ANOINTED FUTURE TOO
DAYCARE

5842 HICKORY GROVE RD.
CHARLOTTE, NORTH CAROLINA

DATE: June 29, 2012

SUBJECT: Administrative Approval for Petition No. 2009-001 Janice White

1 SITE PLAN WITH REVISE CHANGES

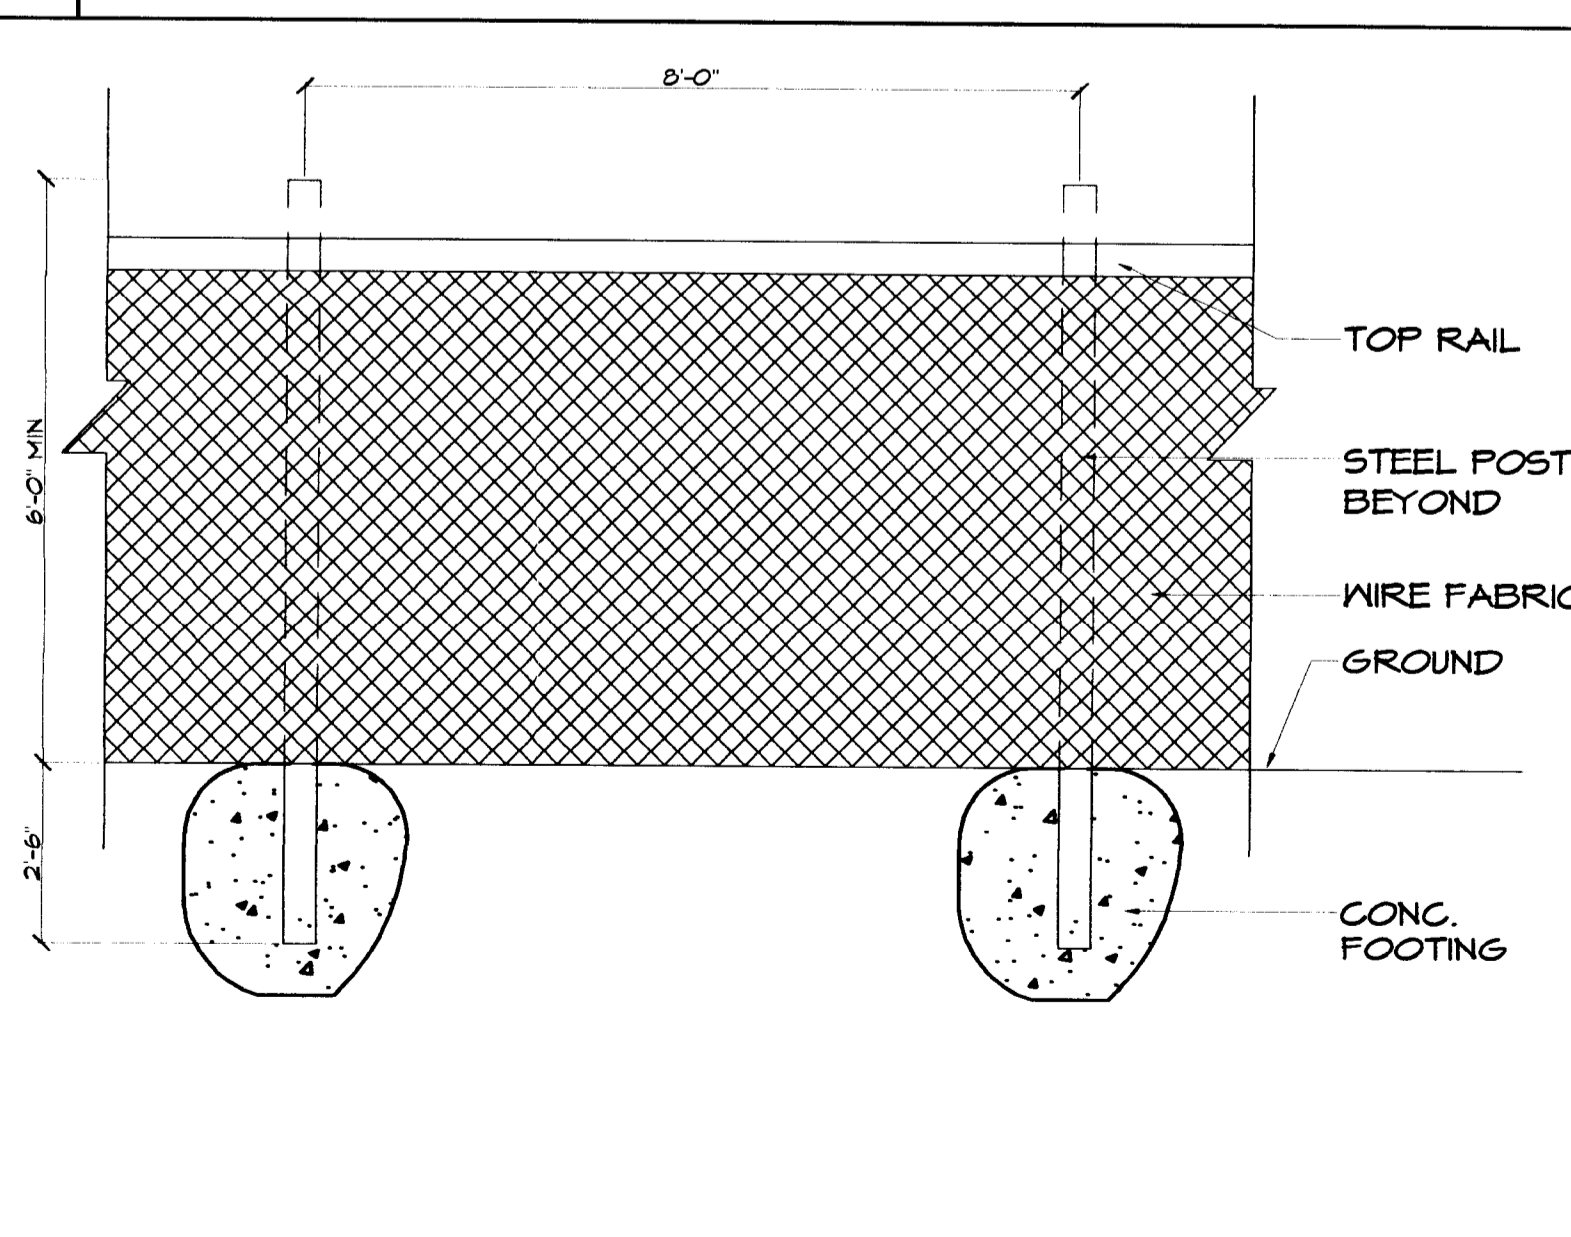
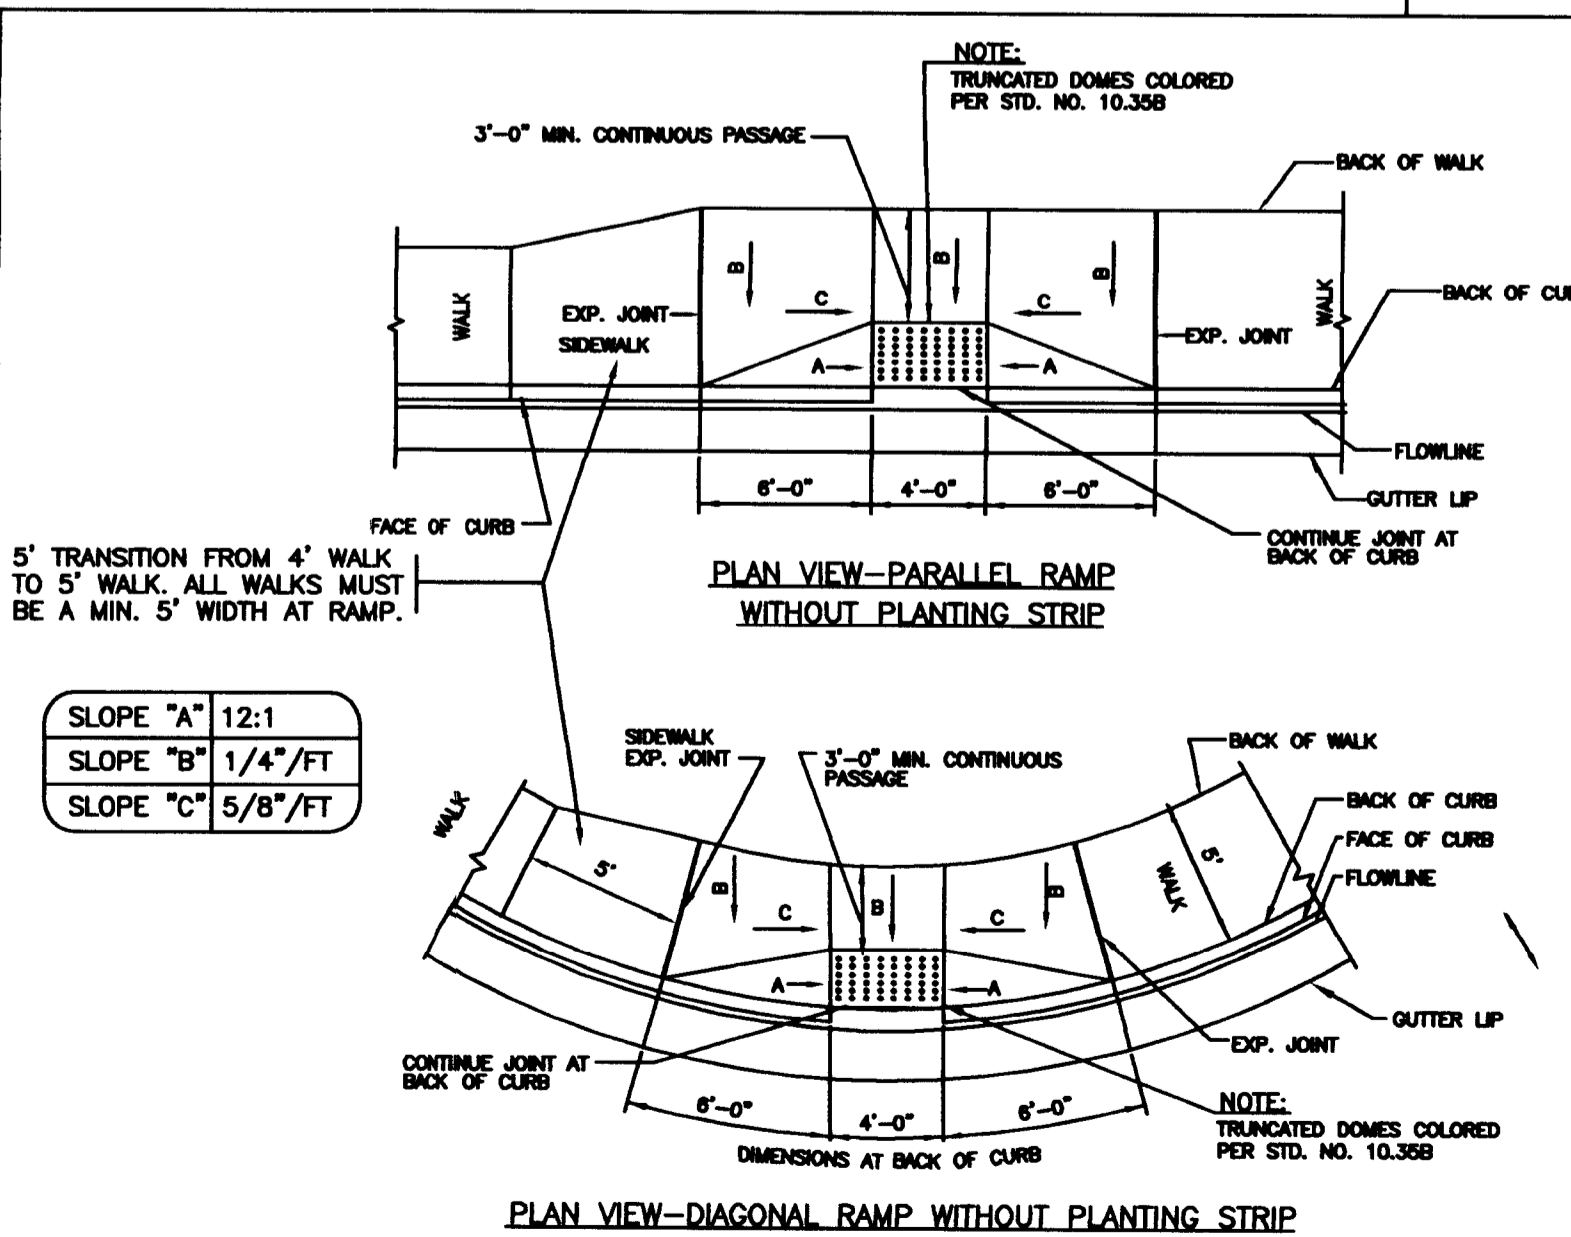
Attached is a revised site plan for the above referenced rezoning petition. The site plan attached allows for a modification of the site to account for the 25% buffer reduction using a fence. Also the plan allows for modification of parking for the site. Since this change does not alter the intent of the development and meets the requirements of the Charlotte Zoning Ordinance Section 6.207 Alterations to Approval, minor changes, I am administratively approving this plan. Please use these plans when evaluating requests for building permits and certificates of occupancy.
